NCC'S COMMENTS AT DEADLINE SIX

A46 Newark Bypass Scheme

Scheme No. TR010065

**Nottinghamshire
County Council**

Figure 6 A17 / Long Hollow Way / Godfrey Drive Roundabout

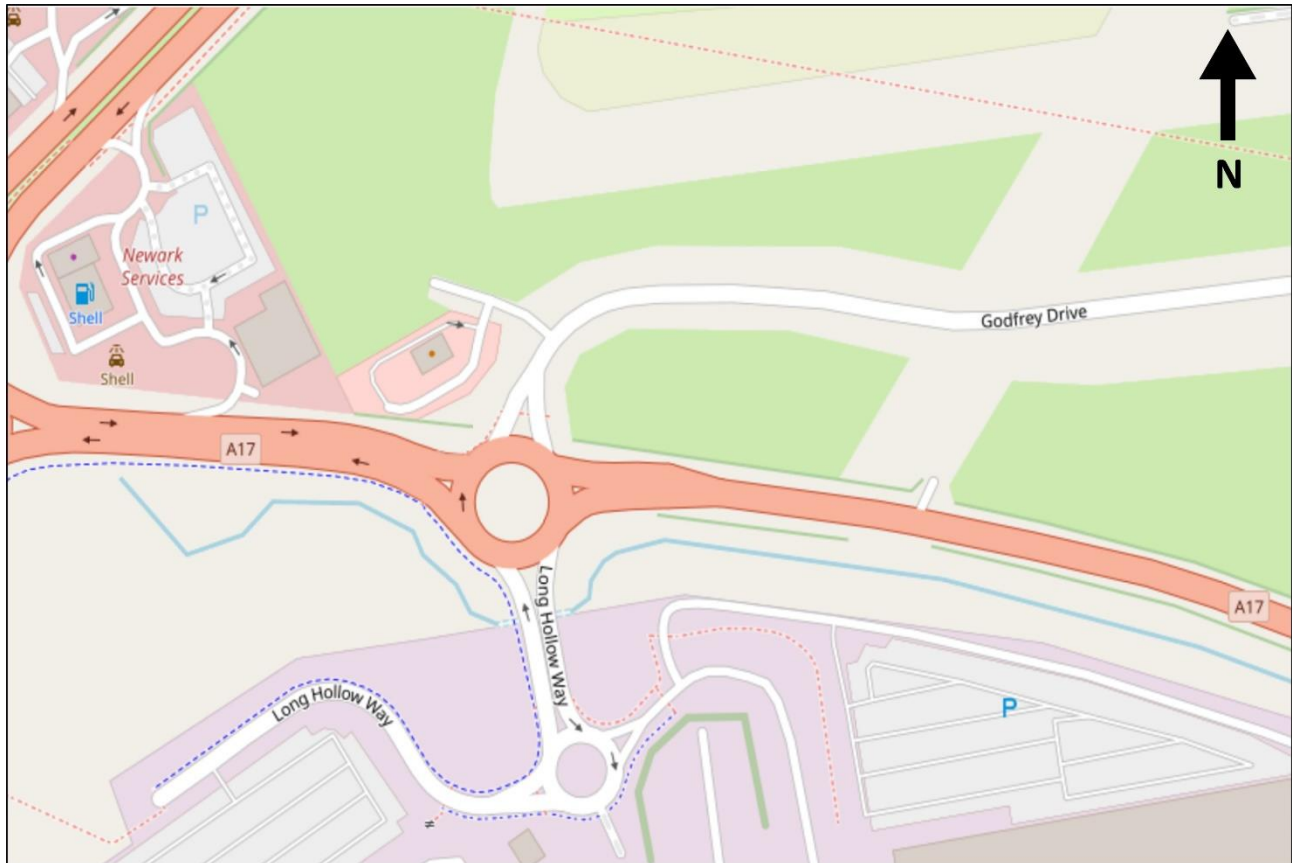
- **A17 / Godfrey Drive / Long Hollow Way**

The VISSIM model structure does not match the current junction lanes and approaches. Godfrey Drive has not been included in the model. The A17 Eastbound exit from the roundabout should be modelled as a 2 into 1 lane merge.

NCC's proposed solution to this matter would be to enter into an agreement with the applicant to adopt a monitor and mitigate approach at this junction.

Appendix Figure A-4

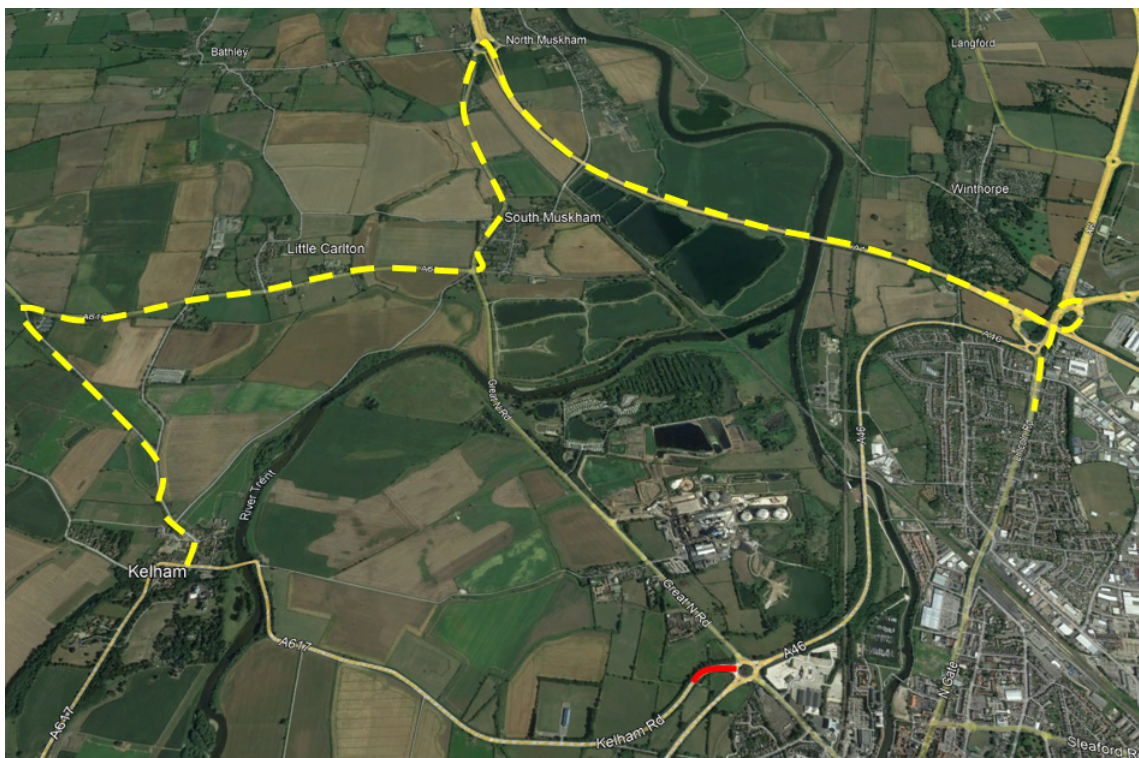
<p>A.1.4 Fosse Road and Farndon Road</p> <p>A.1.4.1 Overnight closures between 21:00 and 06:00 would be required on the Fosse Road and Farndon Road at Farndon roundabout for the tie-ins of the new pavement into the existing and installation of temporary traffic management.</p> <p>A.1.4.2 The diversion route for the Farndon to Newark traffic would be via Hawton Lane, Newark Road and Hawton Road.</p> <p>A.1.4.3 This diversion is detailed in Appendix Figure A-4</p>	<p>The plan shows the A46 mainline closed and part of the A46 Farndon Roundabout. If this plan is trying to show that the access to the A46 roundabout is blocked by the works for Farndon Road, Newark and Fosse Way, Farndon then the diversion route is still not acceptable as it travels over a very narrow bridge in Hawton that is not suitable for this use.</p> <p>If the intention is to link Fosse Way to Farndon Road the diversion route should be –</p> <p>(Old A46) Fosse Road – Lodge Lane – Brecks Lane – Elston Lane – Station Road – Staunton Road – Grange Lane – Bowbridge Lane – Bowbridge Road – Boundary Road – B6166, Victoria Street – B6166, Farndon Road and vice versa.</p> <p>If the intention is just to get the local traffic to the A46 and then could have that dealt with by the A46 diversions which may or may not be in place then it would be: Fosse Way, Farndon - Fosse Way – Lodge Lane – A46 and Farndon Road, Newark – B6166, Victoria Street – B6166, Portland Street – B6166, Lombard Street – B6166, Castle Gate – B6326, Beast Market Hill – B6326, Great North Road – A46</p>	<p>The diversion described in Appendix A1.4 is for the resurfacing and tie-in works between the A46 roundabout and the widened A46. This will require a diversion for both local and strategic traffic. The strategic traffic will use the diversion described in A.1.1. Via are correct that the intention is to link Farndon Road and Fosse Road.</p> <p>The Applicant notes that the diversion route proposed by Via is approximately 12.6 miles against the 3.7 miles via Hawton Lane. The concern is that local traffic will simply use the route that is known to be shorter. The Applicant therefore proposes the following solutions:</p> <ul style="list-style-type: none"> i) The Applicant to install temporary traffic lights on Hawton Lane, at the Hawton Bridge to control traffic during the diversion. ii) NCC/Via and the Applicant to review the feasibility of the Southern Link Road as a local traffic diversion for this closure. <p>The Applicant will include the temporary traffic light control at Hawton Lane bridge in A.1.4 in the Deadline 6 submission of the OTMP and would like the opportunity to discuss with NCC and Via.</p>	<p>The applicant informed the County/Via that this would be for 1-2 nights use only.</p> <p>Via advised that the Southern link Road should be open in 2028 and would direct the applicant to use this as an alternative diversion route.</p> <p>The applicant agreed to update the OTMP for deadline 6 in line with the above, specifying the time periods for closures.</p>

Appendix Figure A-6

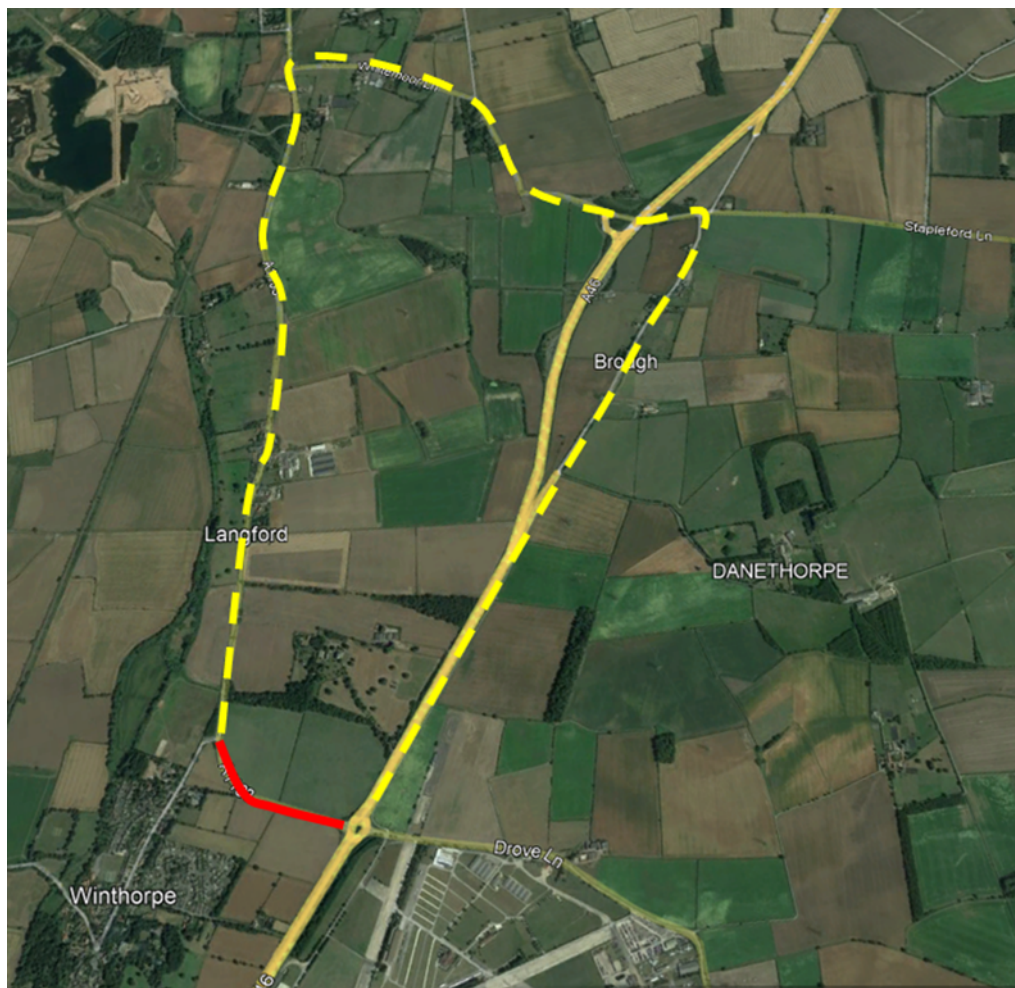
<p>A.1.6 A1133</p> <p>A.1.6.1 Overnight closures between 21:00 and 06:00 would be required on the A1133 between the Gainsborough Road junction and the Winthorpe Roundabout for the installation of temporary traffic management and tie-ins of the new pavement into the existing.</p> <p>A.1.6.2 The diversion route would be via the A1133, Whitemoor Lane, Brough Lane and the A46.</p> <p>A.1.6.3 This diversion is detailed in Appendix Figure A-6</p>	<p>This route uses a narrow unclassified road and is not suitable. The route that is usually used for a planned closure at this location is either: A1133 – A57 – A46 (Through Lincolnshire’s area) or A1133 – A57 – A1 –A46 (This section also strays into Lincolnshire at certain points)</p>	<p>The Applicant notes Via's points on the condition of Whitemoor Lane and Brough Lane. The Applicant will amend section A.1.6 to include Via's proposed diversion route which will be included within the Deadline 6 submission of the OTMP.</p>
